Civil / Stormwater Responses to SSD 6962 BCC Conditions – 60 Wallgrove Road, Eastern Creek

Further to our meeting with you on the 28th of September, please find below a detailed summary of the points raised by Council in your letter dated 7th September 2015.

No.	Proposed Condition	AT&L / Mirvac Comments
2.7.1	Amended drainage plans from AT&L consultants (reference 12-108, revision B dated 28 May 2015) are to be provided to meet the requirements under Council's DCP Part R 2006 and Councils Engineering Guide for Development 2005. The amended plans must address the following:	Condition accepted – No changes proposed.

Status	FOR APPROVAL NOT TO BE USED FOR CONSTRUCTION	A1
Drawing No.	DAC033	Issue
Project No.	12-108	B

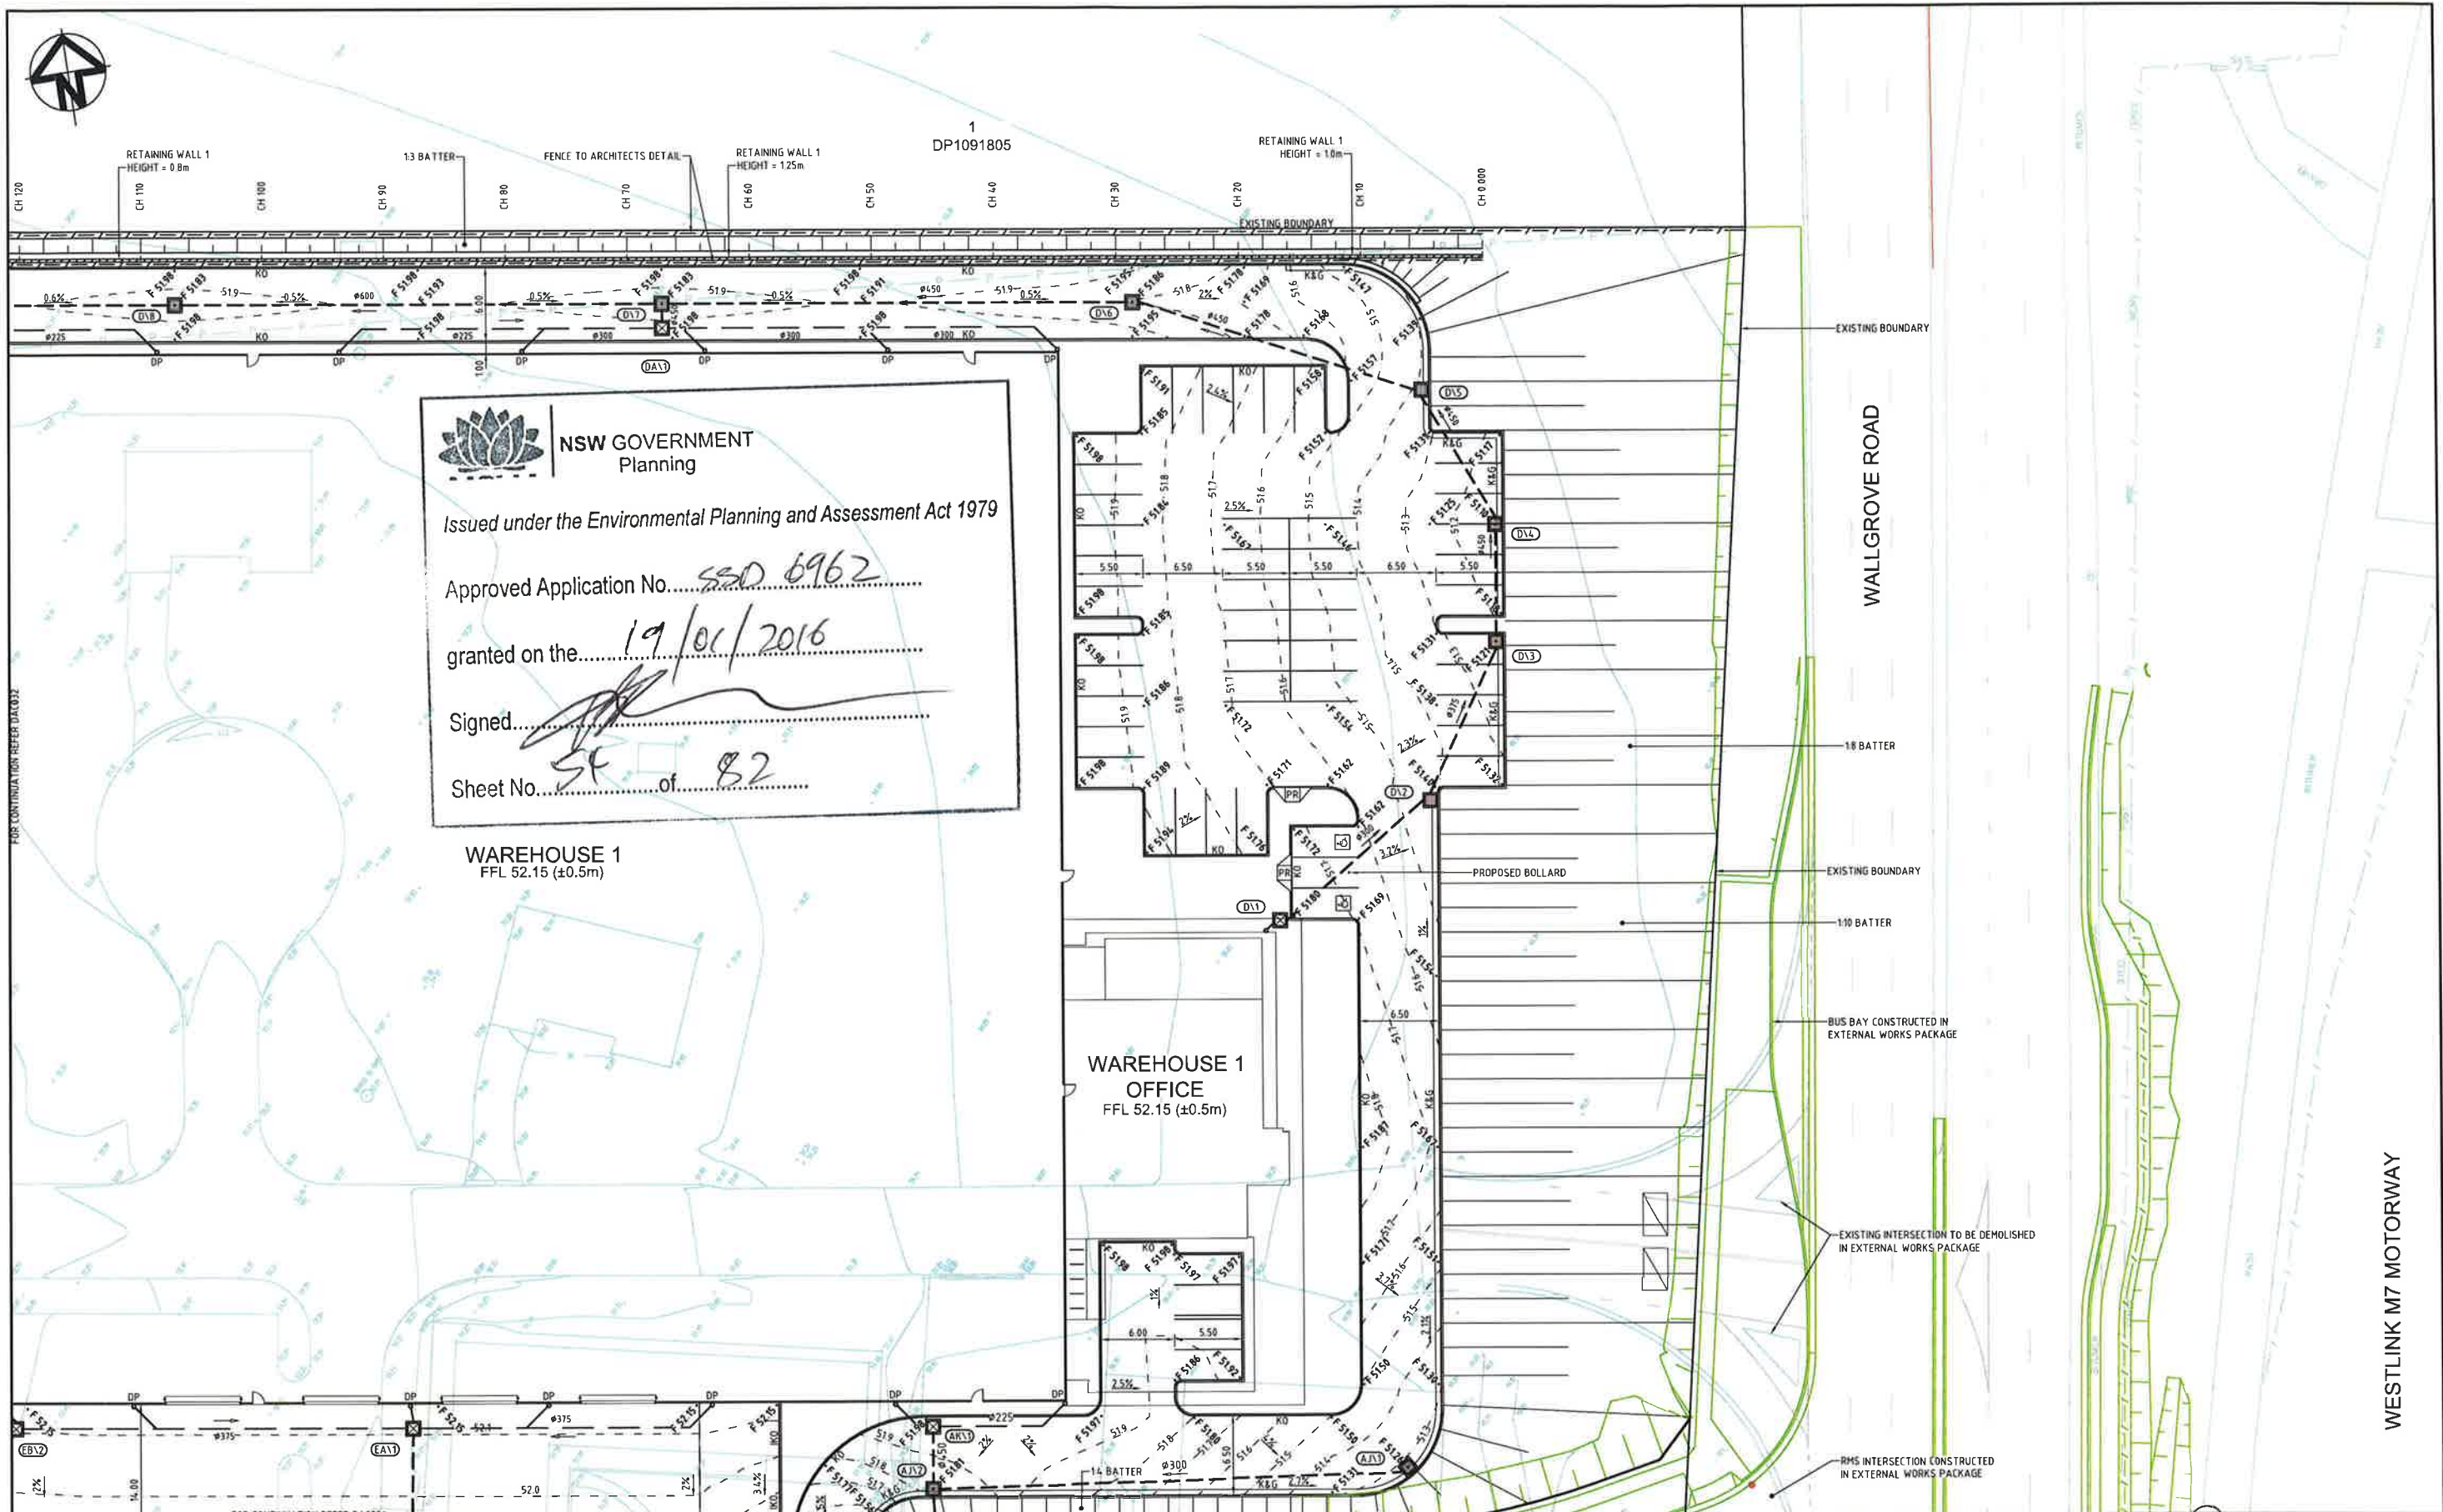
2.7.2 (vii)	On plan DAC033 reconfigure the drainage for 50% of roof water to discharge direct to the rainwater tanks and not to the surface drainage system.	To be deleted. Refer to new clause 7.1.12. <u>2-7-12</u> ?	OK.

F:\12-108 Walgrove Rd Leadin DA\Drgs\Civil\DA-Drawings\DAC034.dwg

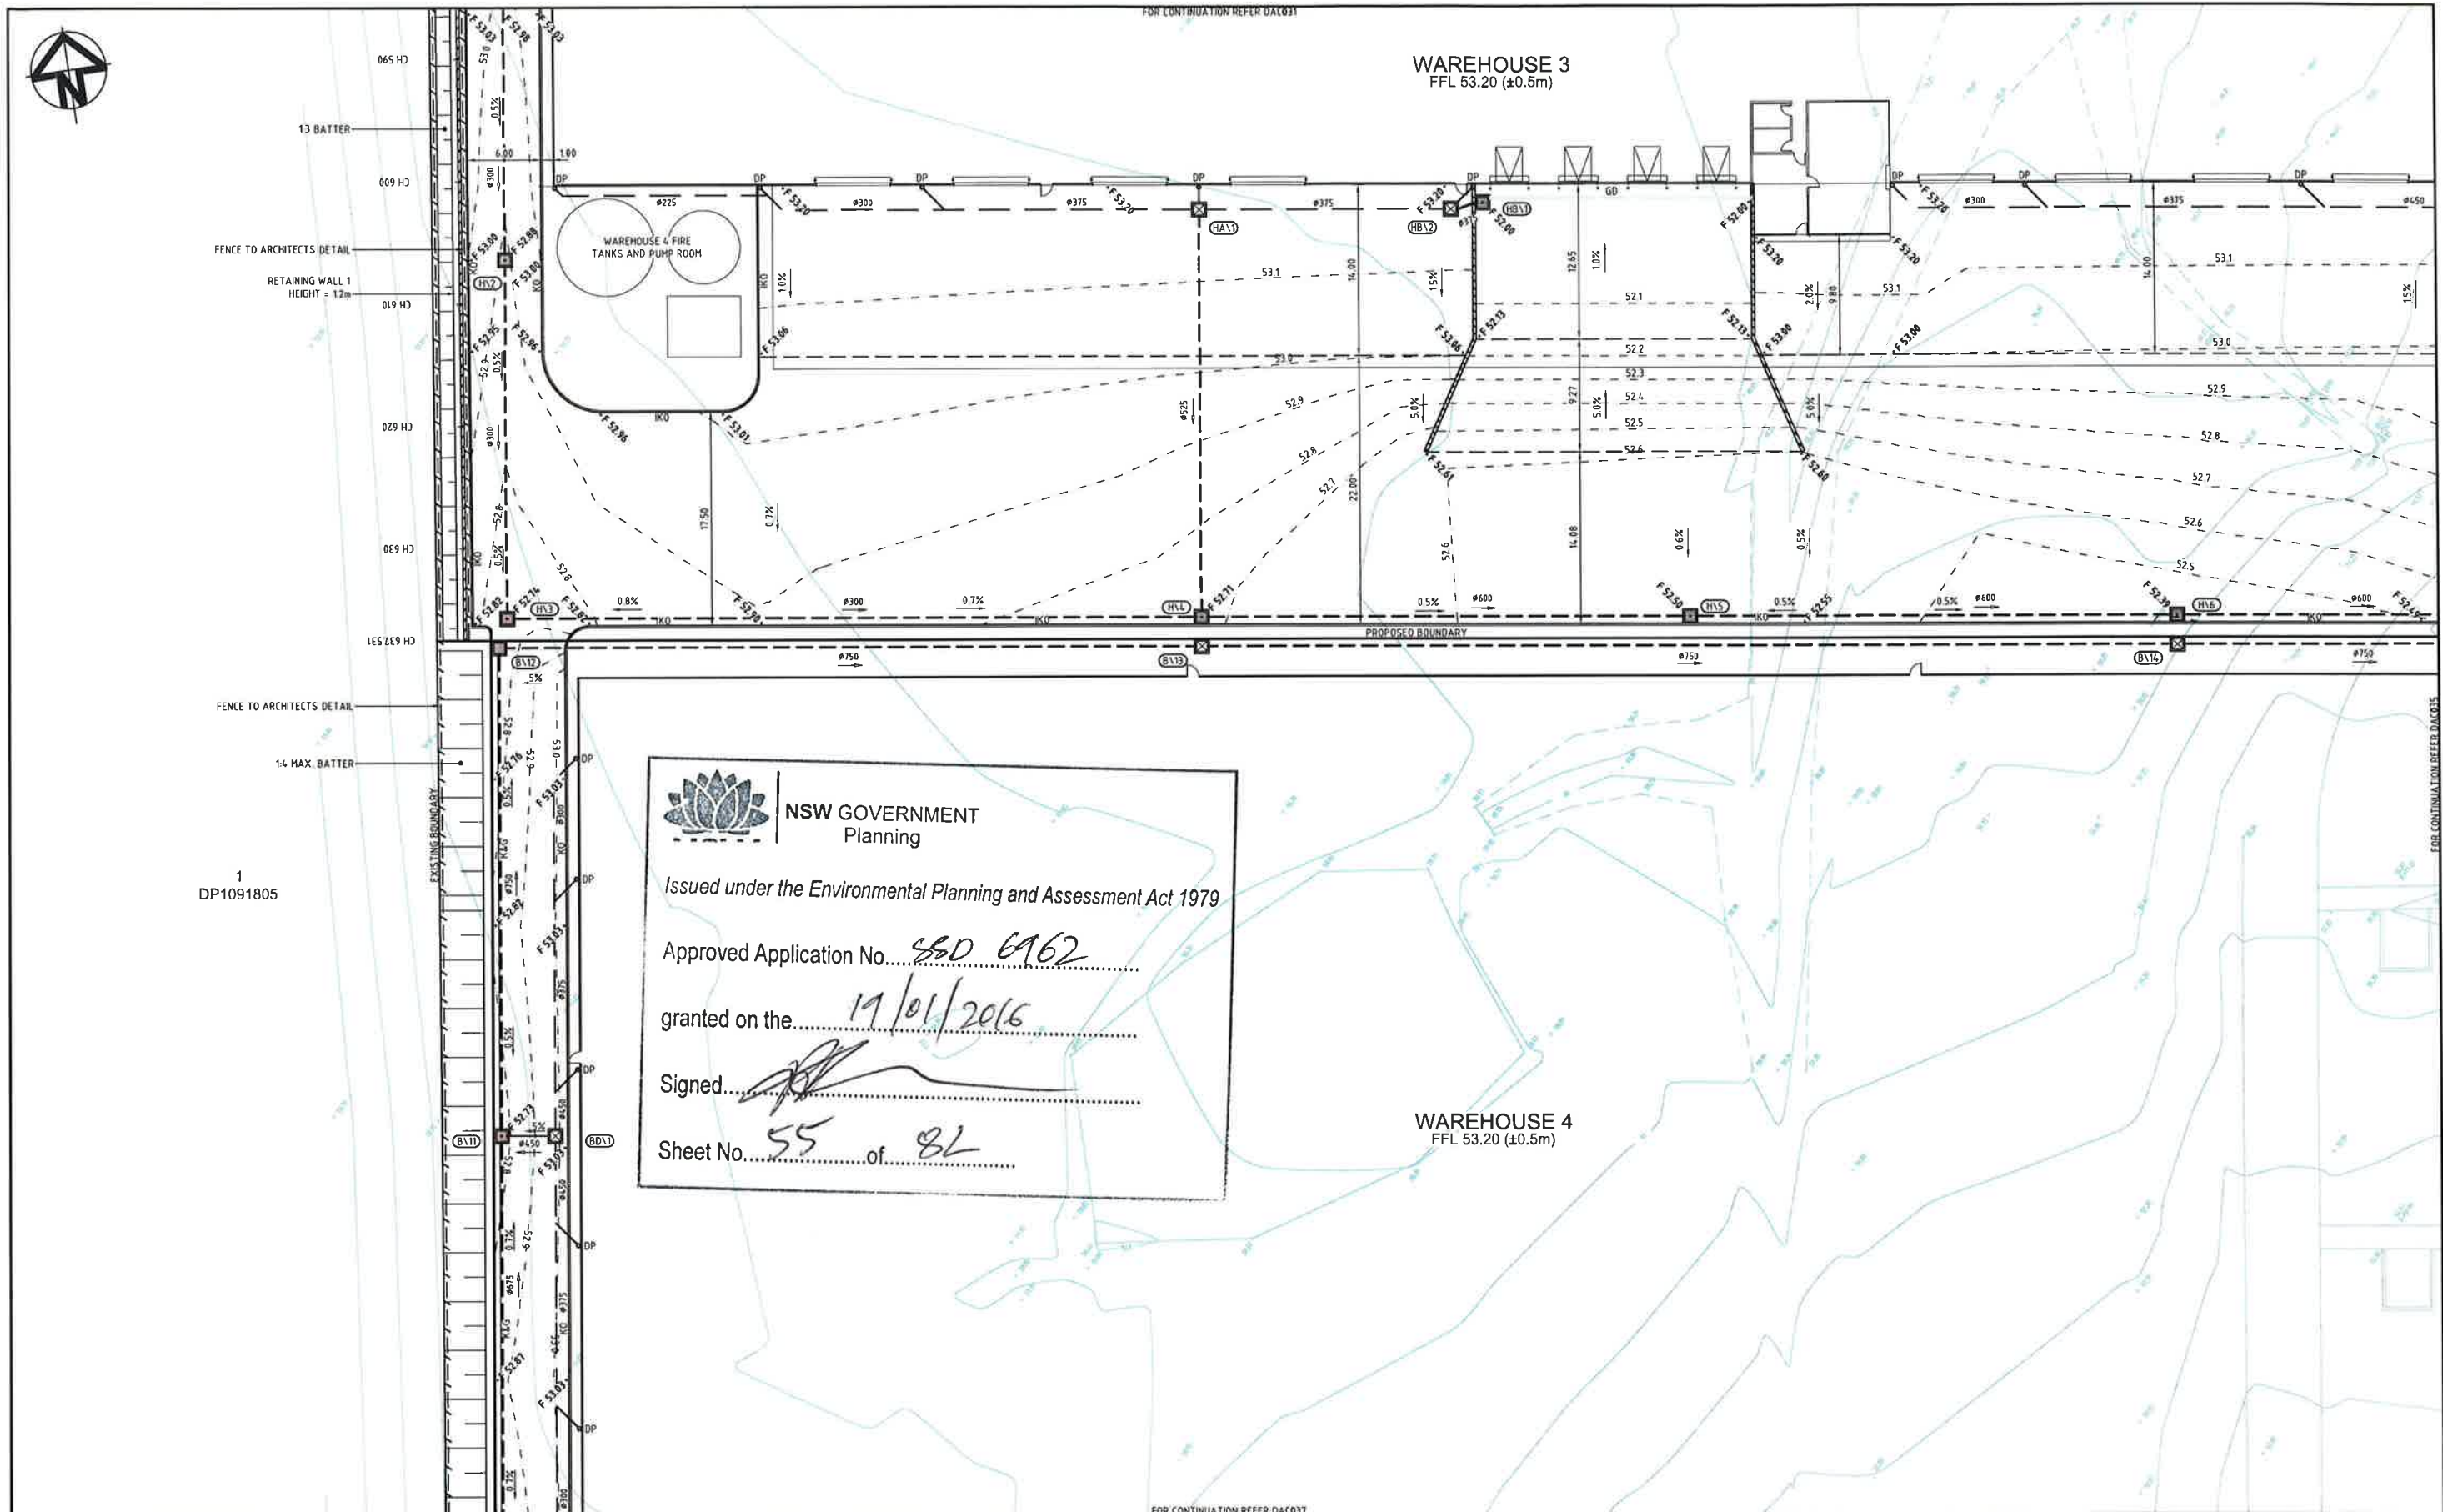
2.7.1 (viii)	On plan DAC034 reconfigure the drainage for 50% of roof water to discharge direct to the rainwater tanks and not to the surface drainage system.	To be deleted. Refer to new clause 7.1.12. 2.7.12	OK

Drawing No. DAC037	Project No. 12-108	Issue B
------------------------------	------------------------------	-------------------

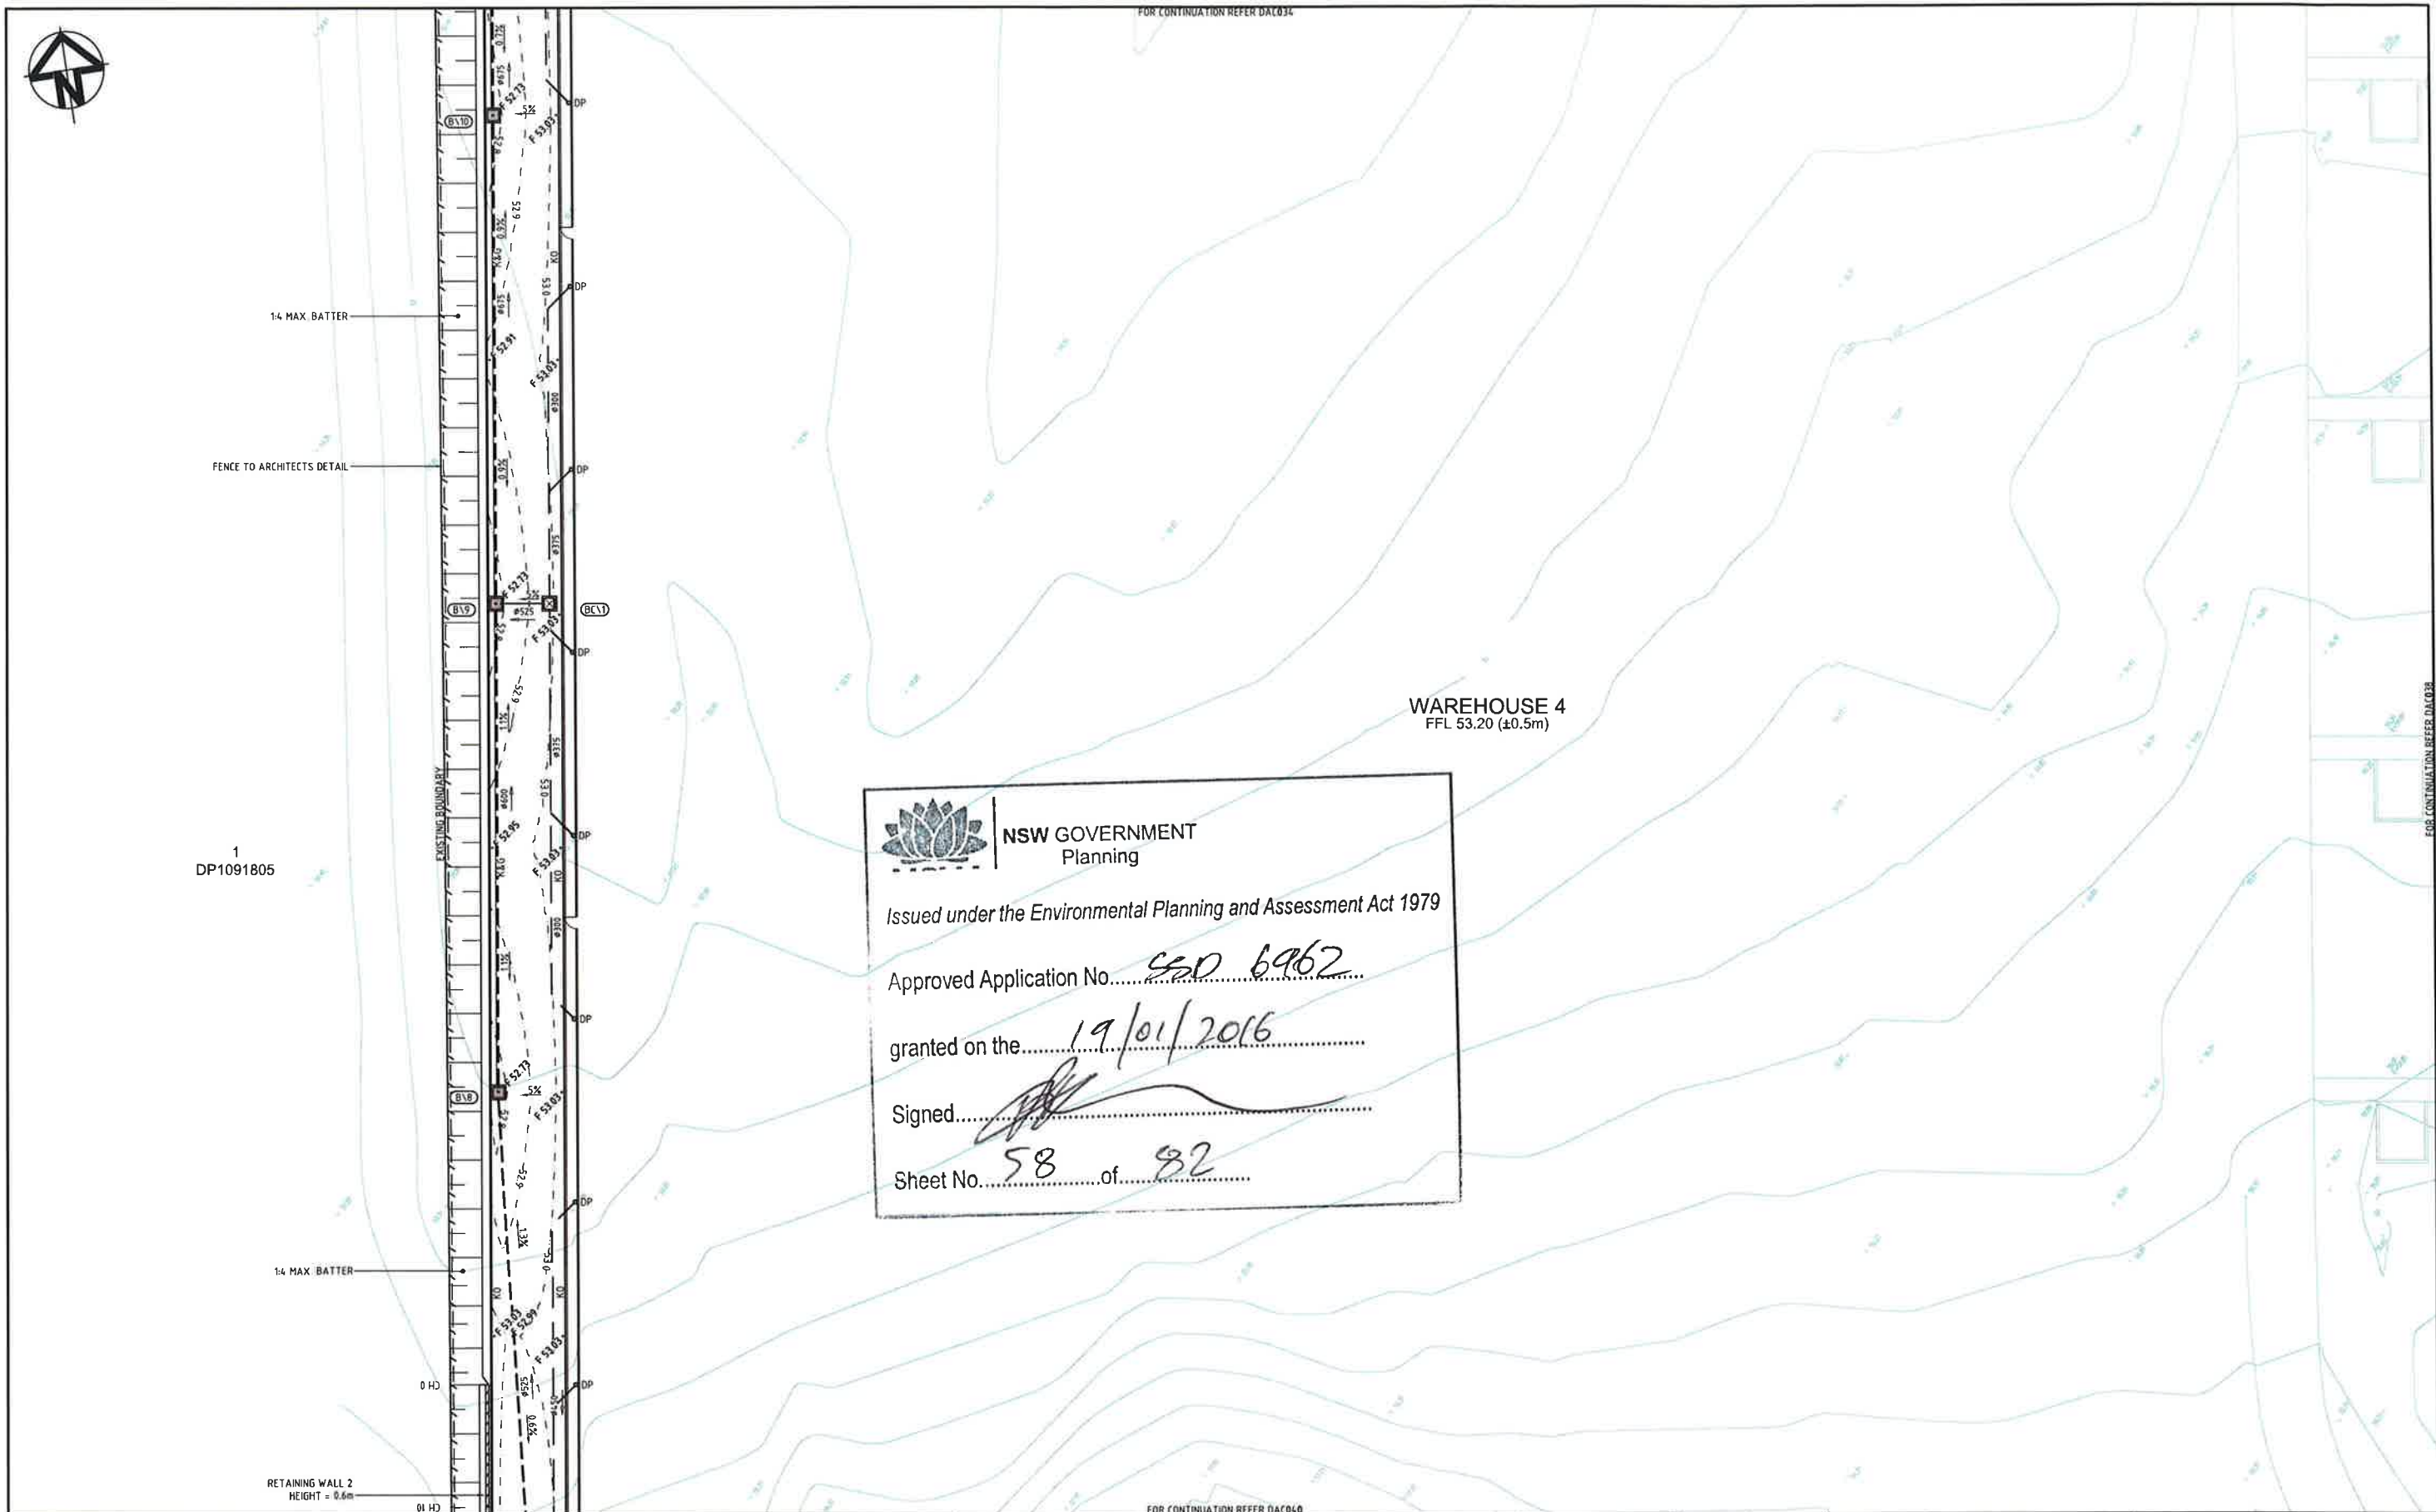
2.7.1 (xi)	On plan DAC037 reconfigure the drainage for 50% of roof water to discharge direct to the rainwater tanks and not to the surface drainage system.	To be deleted. Refer to new clause 7.1.12. 2.7.12	OK
